From: [REDACTED]@gov.wales
To: [Connahs Quay](mailto:Connahs.Quay)
Cc: NorthandMidWalesDevelopmentControlMailbox@gov.wales
Subject: Interested Party Reference number: [REDACTED] - Connah's Quay Low Carbon Power Project, Welsh Government response
Date: 28 May 2026 15:57:04

The Welsh Government, in its capacity as the Overseeing Organisation for the Strategic Road Network (SRN), notes that the Applicant has not yet identified a definitive abnormal load route to the site, nor demonstrated its suitability in accordance with Welsh Government Procedure & Advice Guidance (PAG) "Pulling Together – Best Practice for Transporting Abnormal Loads in Wales".

Environmental Statement Volume III Figure 5-4: Abnormal Load Routing Options

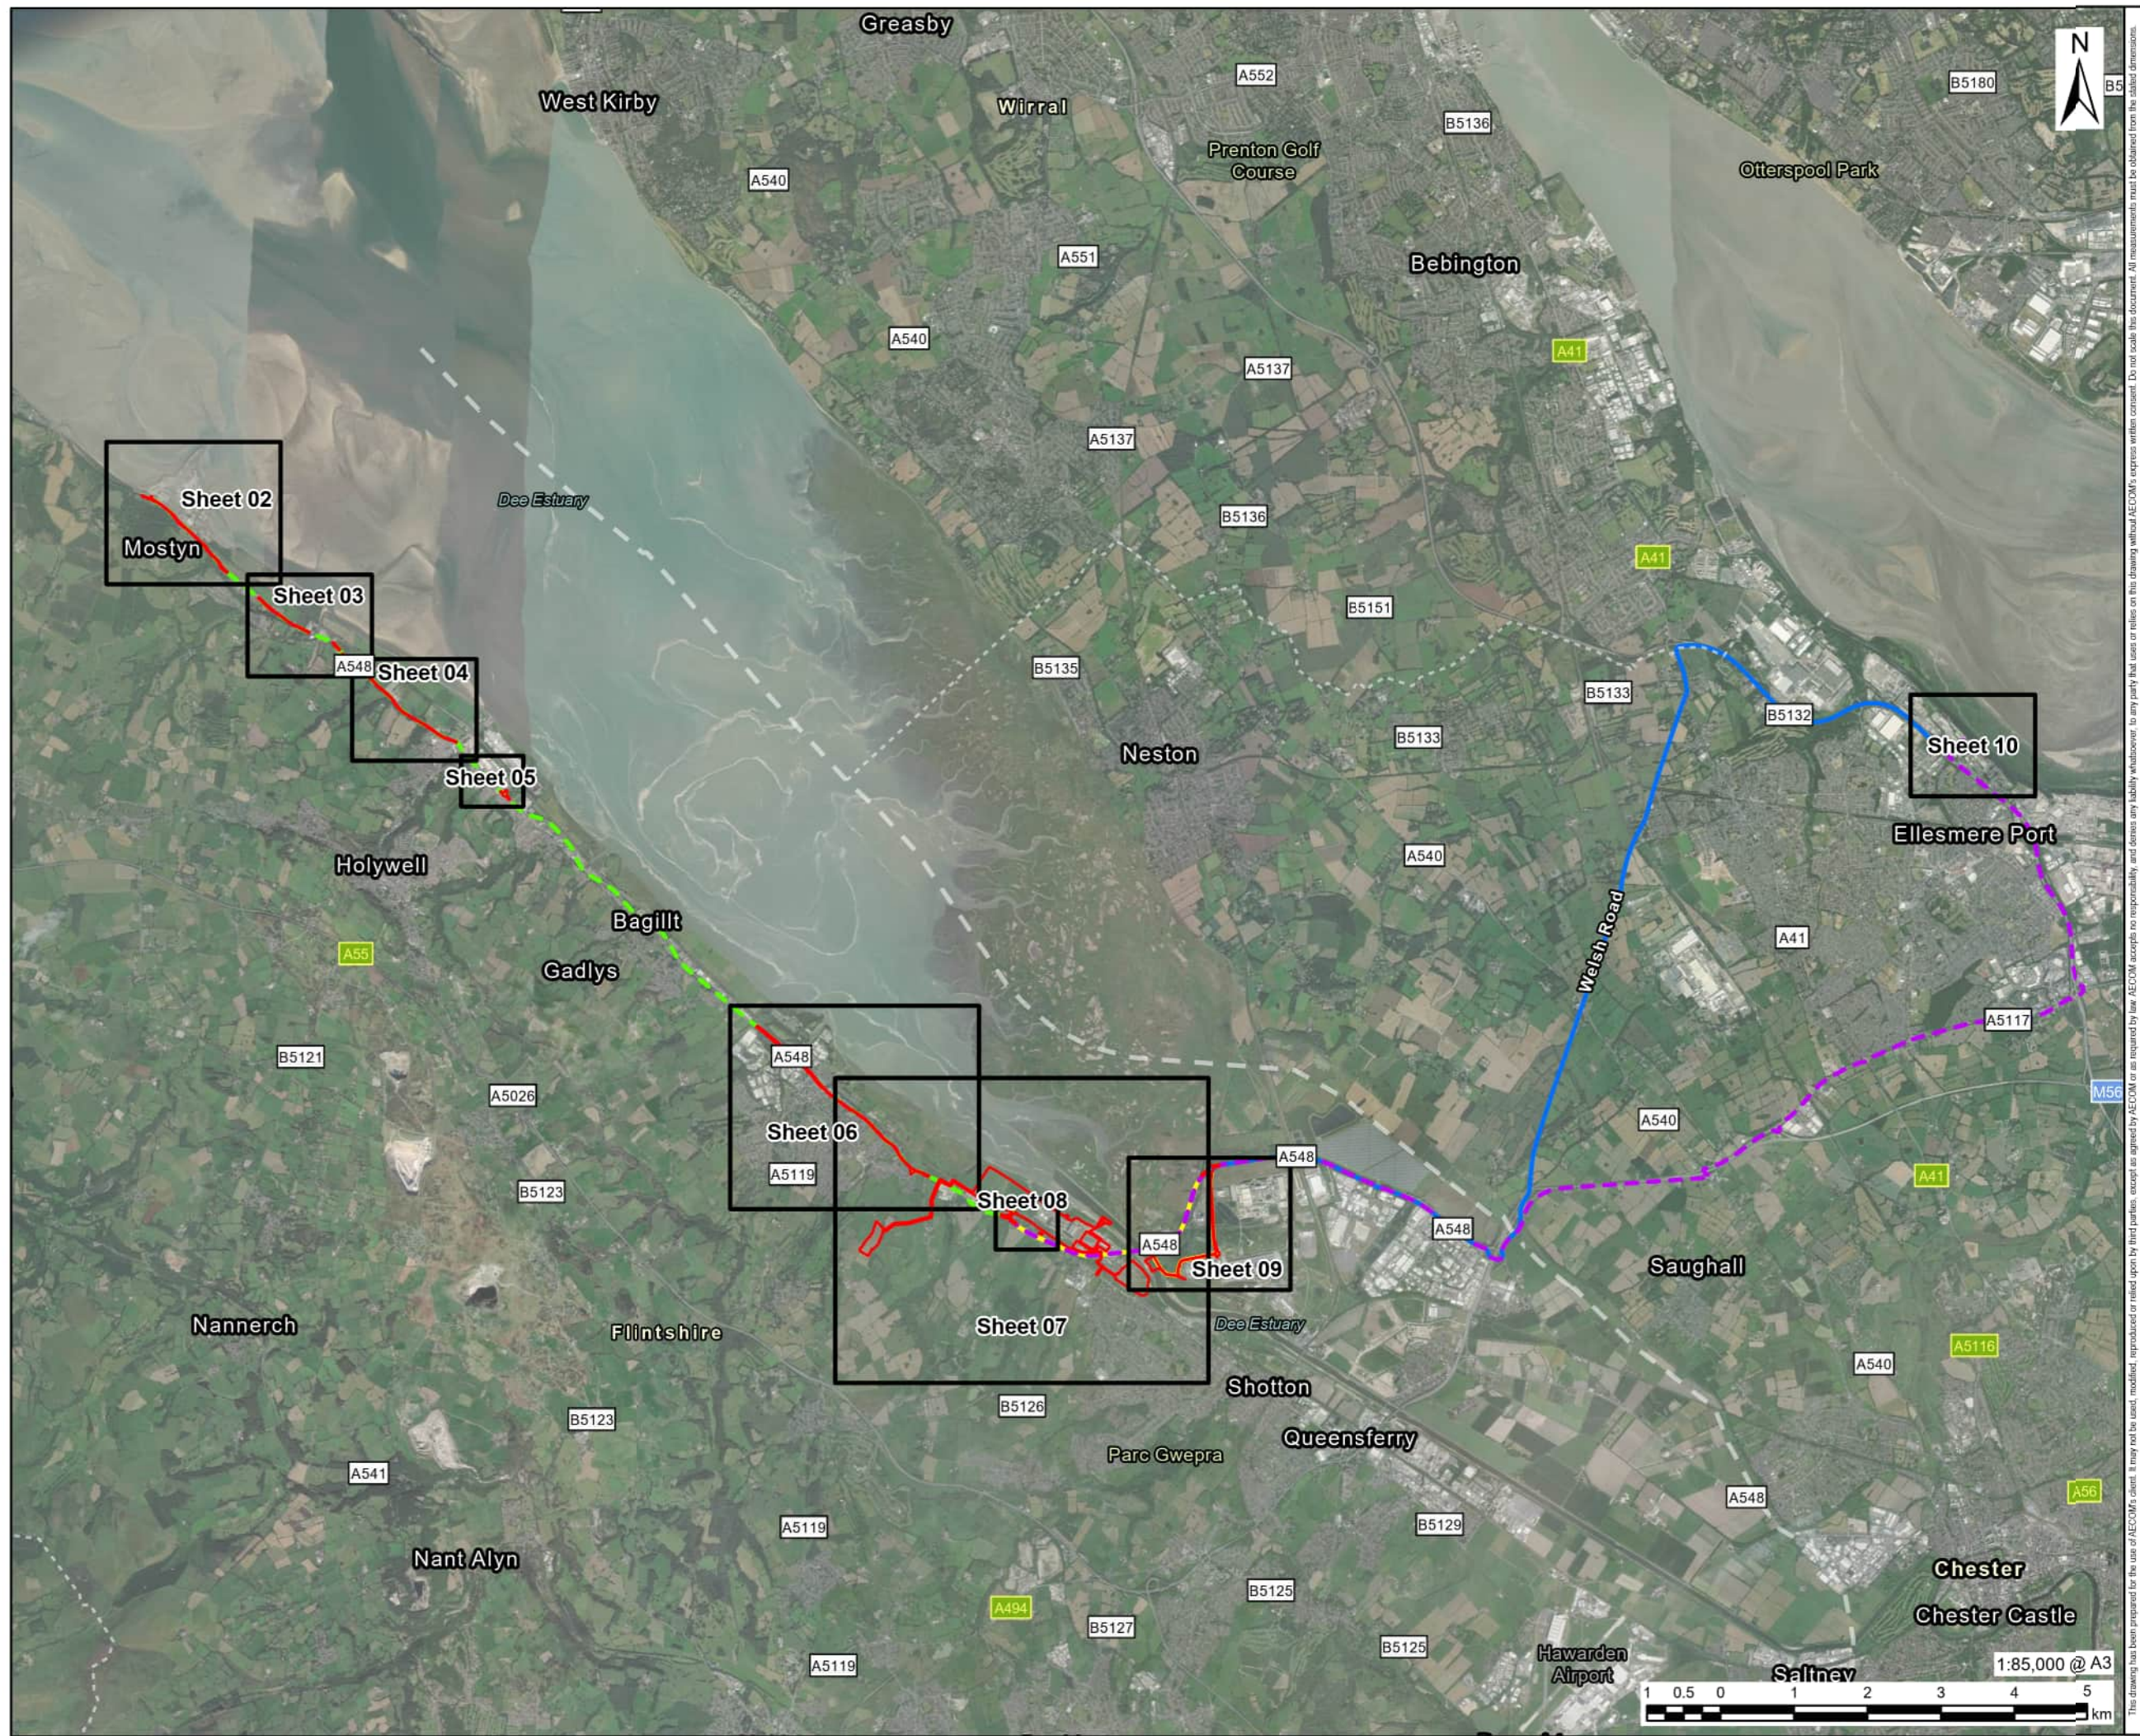
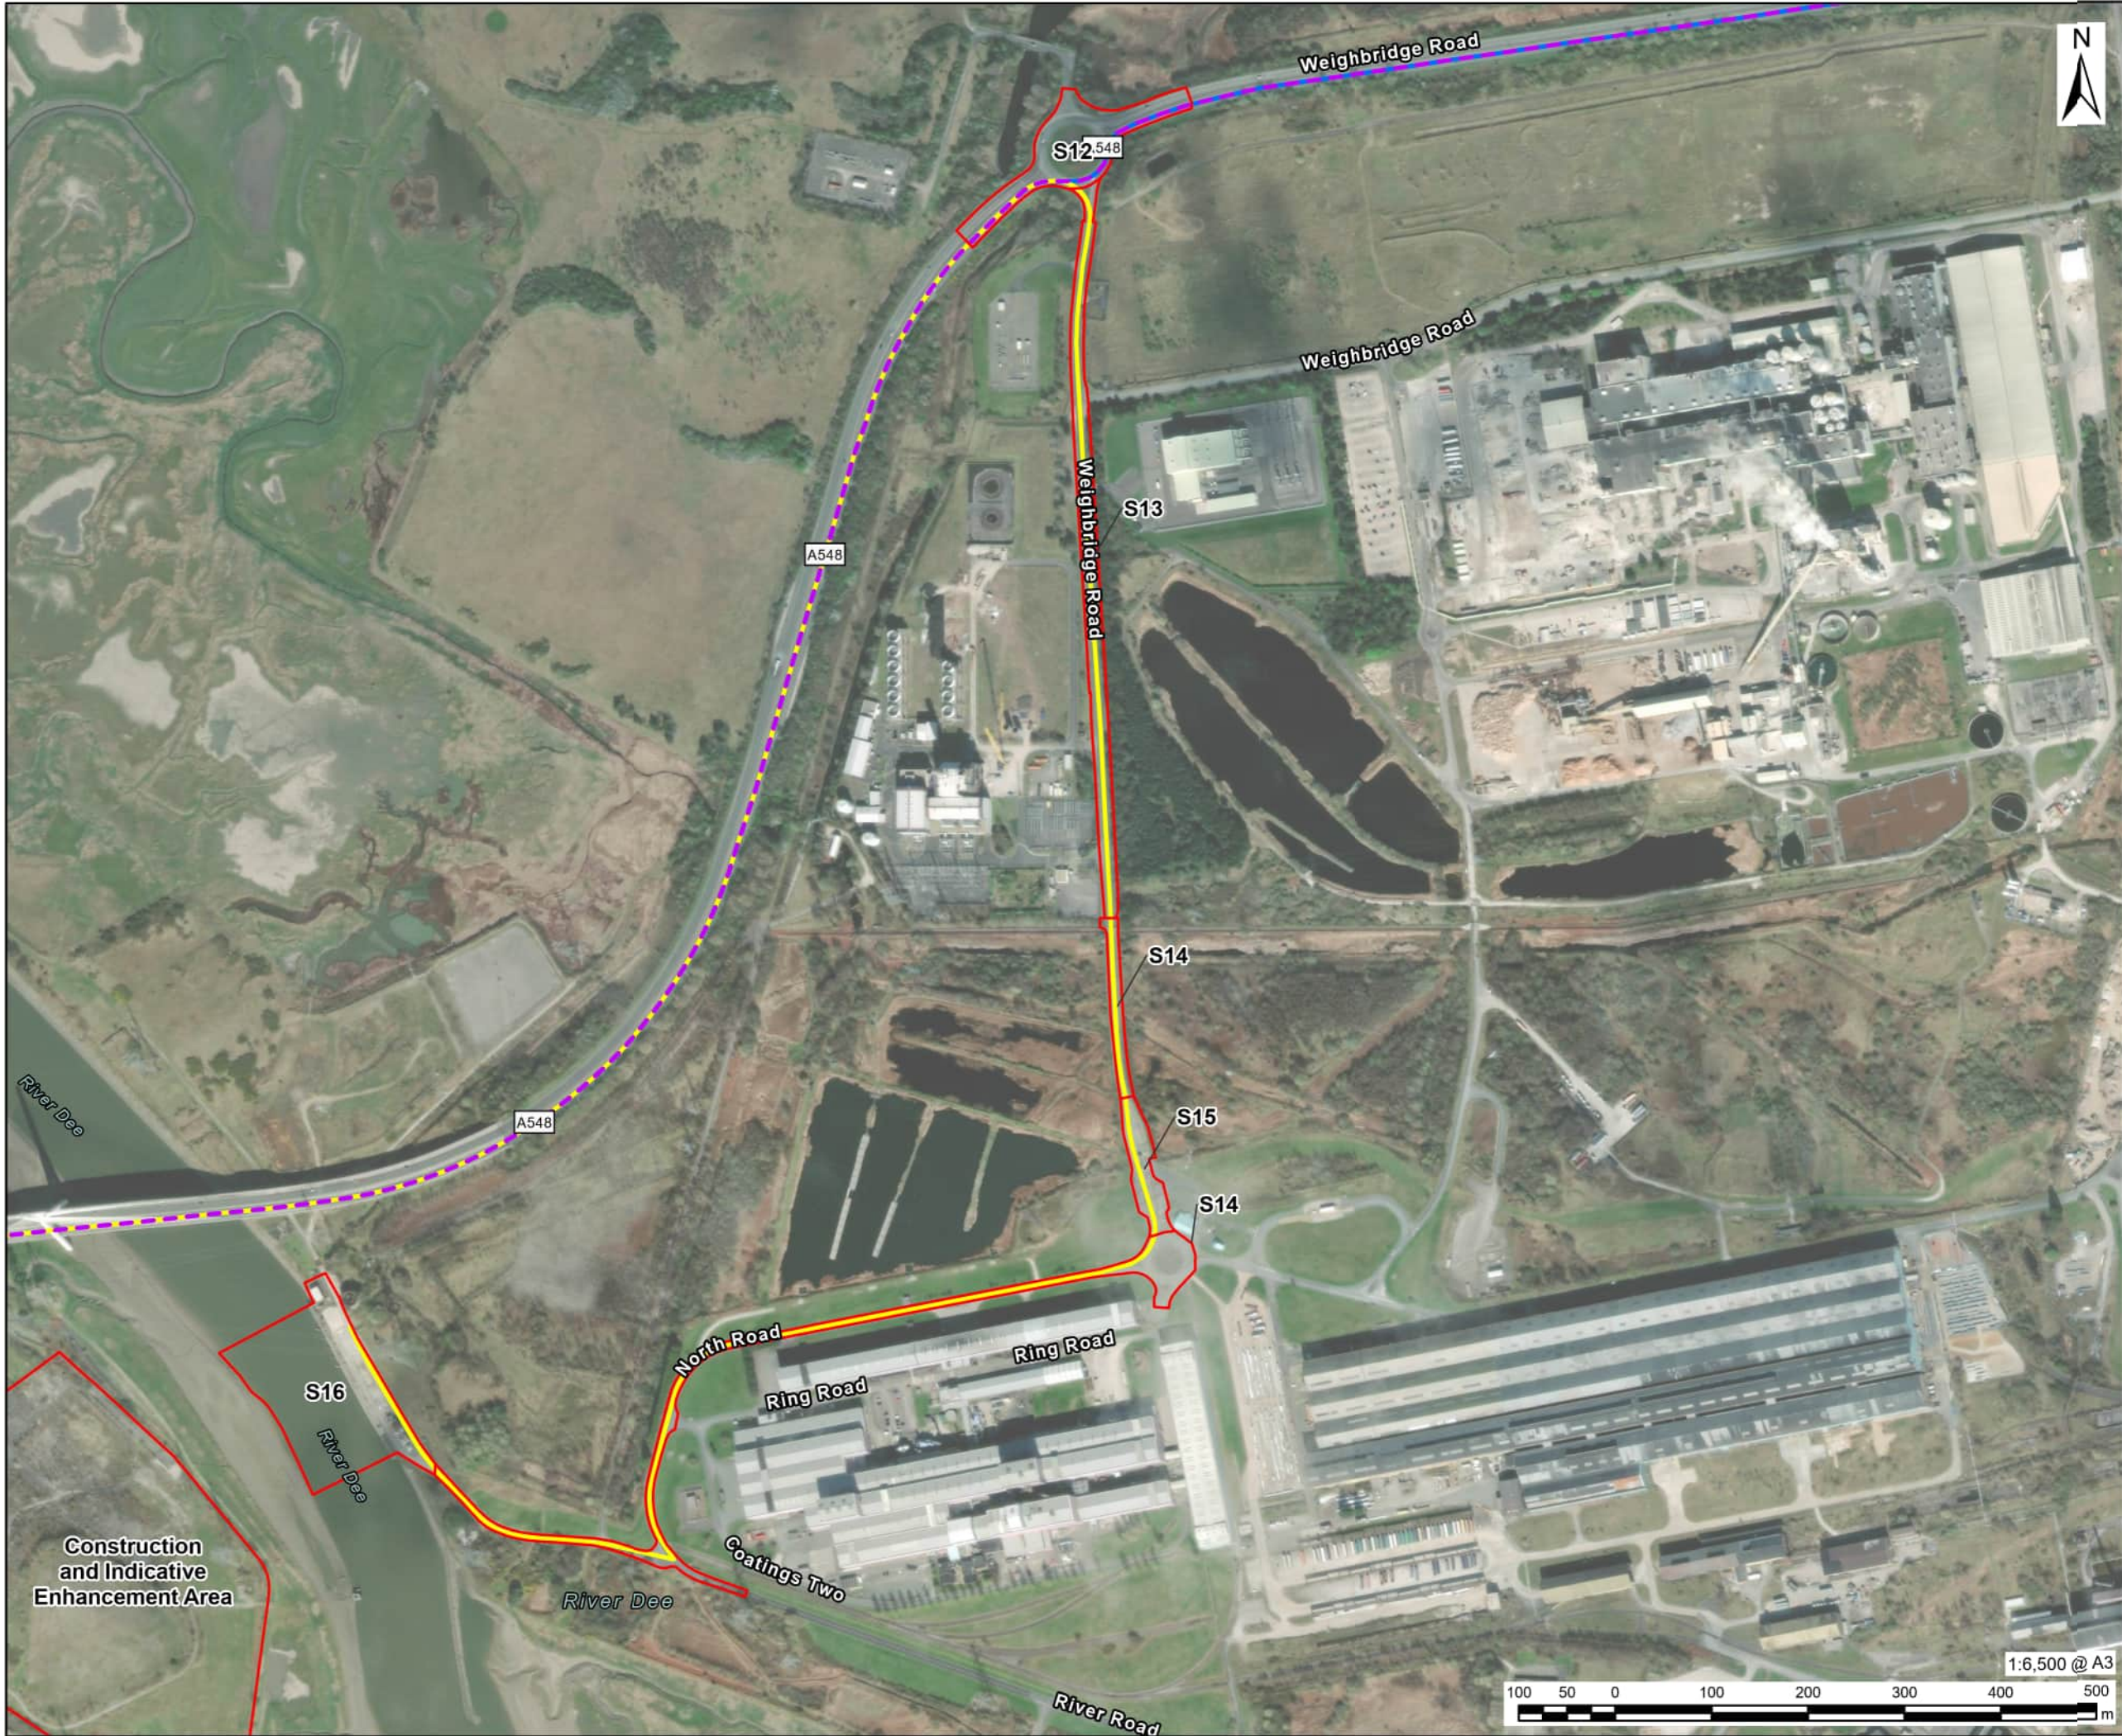
The submitted information appears to rely on a shortlist of potential routes and does not provide sufficient evidence that abnormal loads associated with the Proposed Development can be safely accommodated on the trunk road network.

The Welsh Government therefore requires that a detailed Abnormal Load Transport Strategy be produced and submitted to the Welsh Government for approval in writing by the Welsh Ministers as Overseeing Organisation for the SRN prior to the imposition of a suitably worded condition.

- (a) identification of the route or routes to be used for all abnormal loads;
- (b) evidence demonstrating that the selected routes are suitable, including structural assessments of all affected highway structures;
- (c) swept path analysis and, where necessary, trial run evidence demonstrating that the largest loads can safely traverse the route;
- (d) details of any highway works or temporary measures required to facilitate abnormal load movements;
- (e) a Traffic Management Plan (TMP) for abnormal load movements, including convoy arrangements, escort requirements, timing of movements, contingency planning and stakeholder engagement.
